Urban Design Observations			Officer:	Stephen Kilmartin
Description:	Rowan Cottage			 Ribble Valley Borough Council www.ribblevalley.gov.uk
Application Ref:	2017/0920	Case Officer:	S.K	
Response Ref:	2017/0920/UD/02	Issue Date:	23/10/17

#### PROPOSED REAR ELEVATION

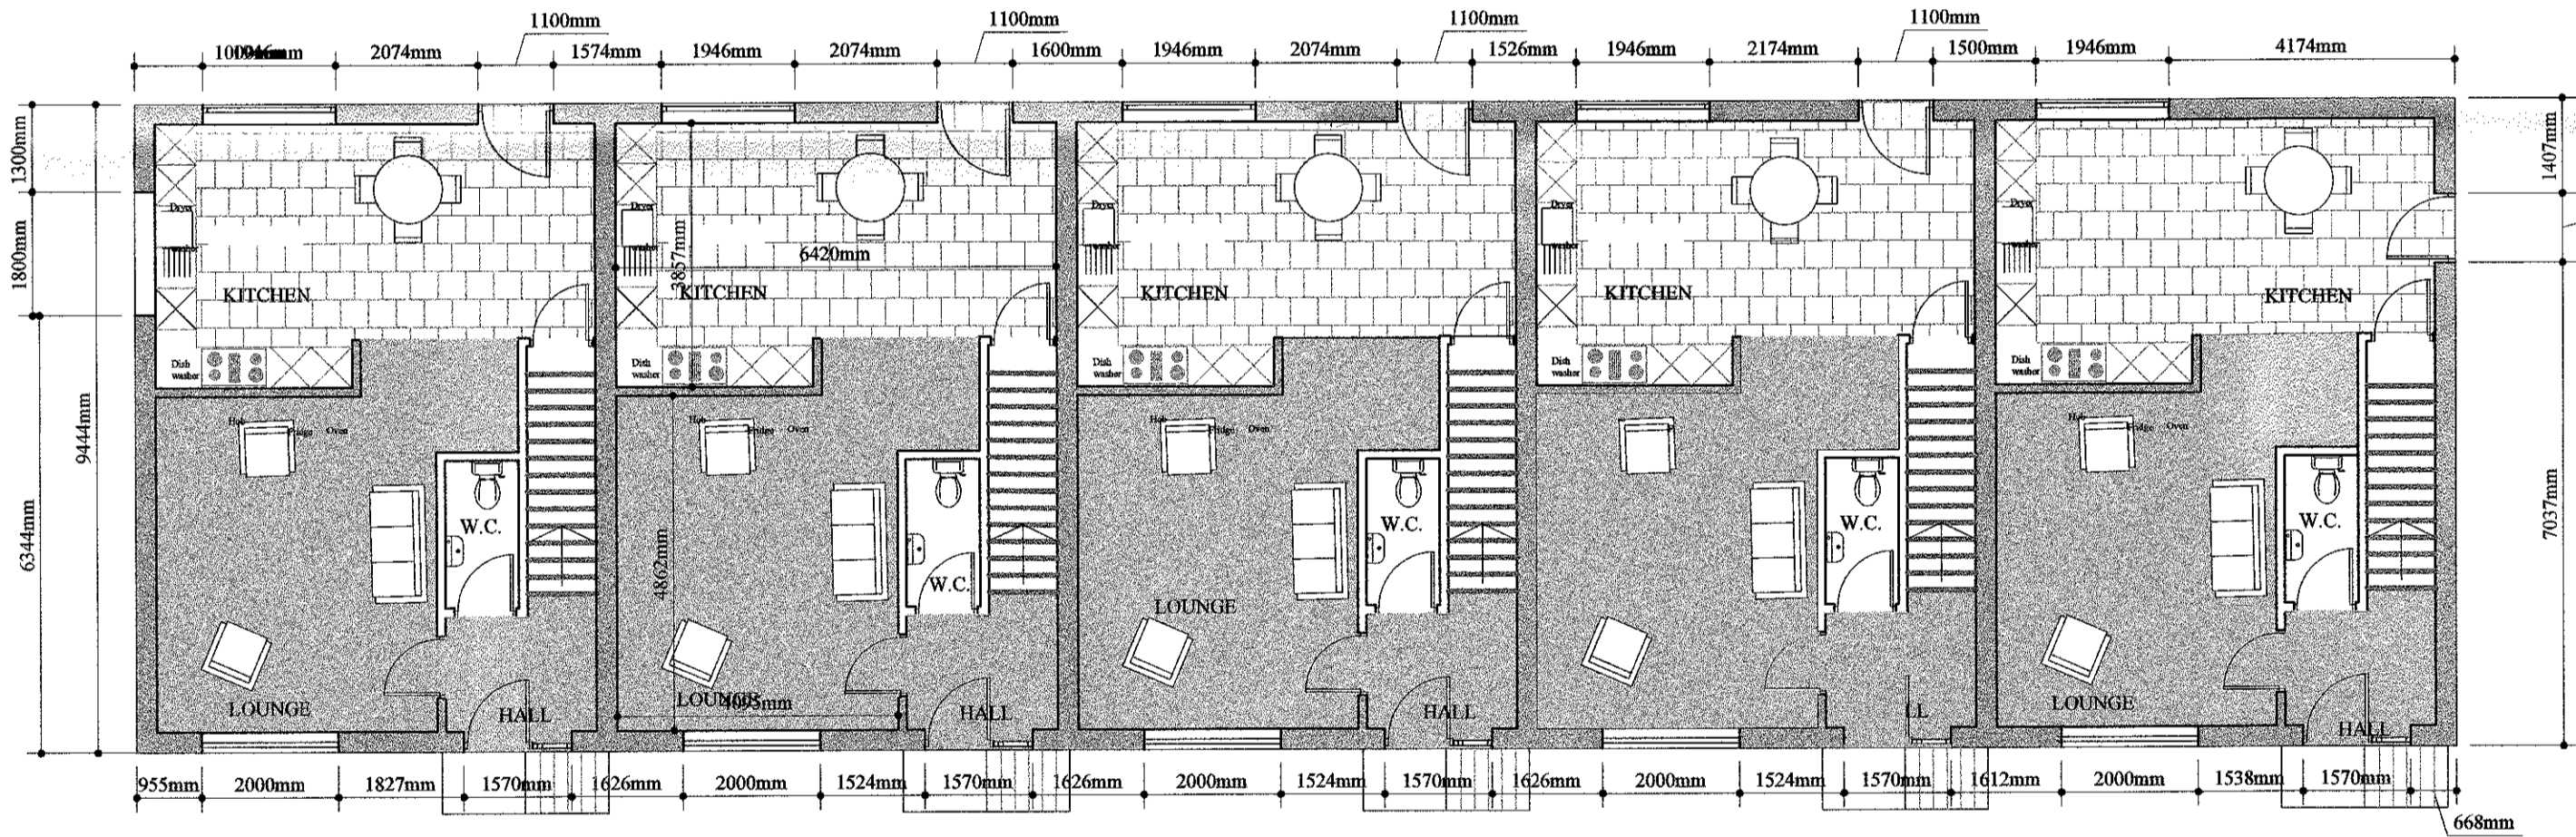
- 1.12** Plot 02 appears to have no allocated bin storage area.
- 1.13** I would ask you consider revising the 'rear' (north) facing elevation of plot 01 to incorporate a front door as per the remaining plots to ensure visual continuity within the terrace.

- 1.14** Reduce the size of the window serving the bathroom on the side elevation (east) of plot 01 and confirm that both windows on this elevation will be obscure glazed.

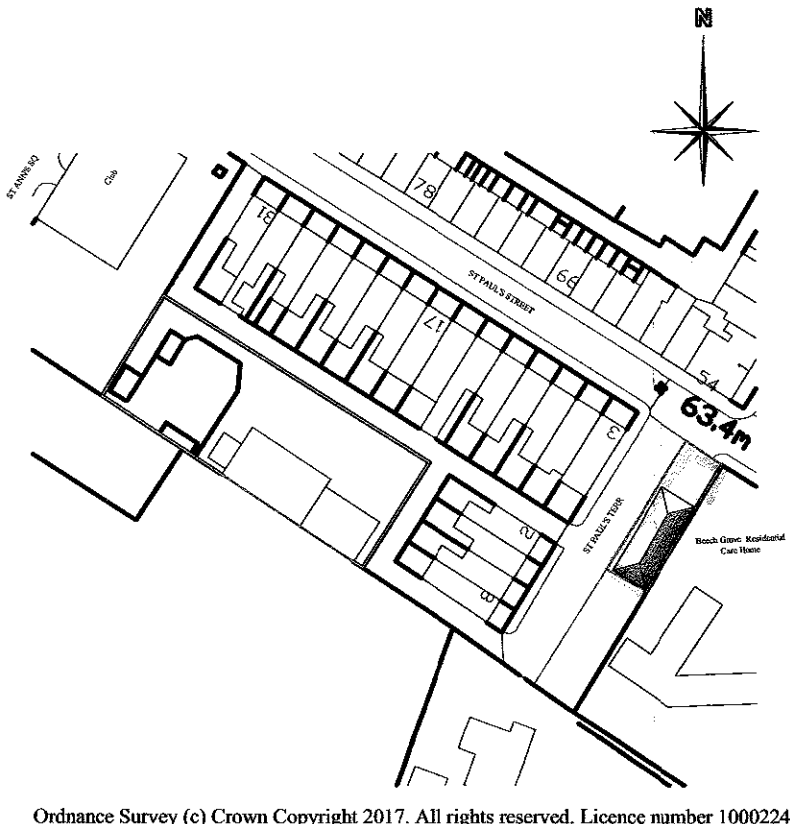
1.3	<i>The proposed garages will be of sufficient size to meet modern standards in that there is enough internal space to accommodate both a family car and some cycles and therefore would assist the sustainability of the development. The position of the garages indicates that there is 8m between the doors and kerb line of St Pauls place and so will allow the garages to be functional even when cars are parked adjacent to No 3 Saint Pauls Street. Considering these design factors I would not have highway issues with the garages as long as they were built with roller shutter or similar doors that remain within the confines of the garage.</i>
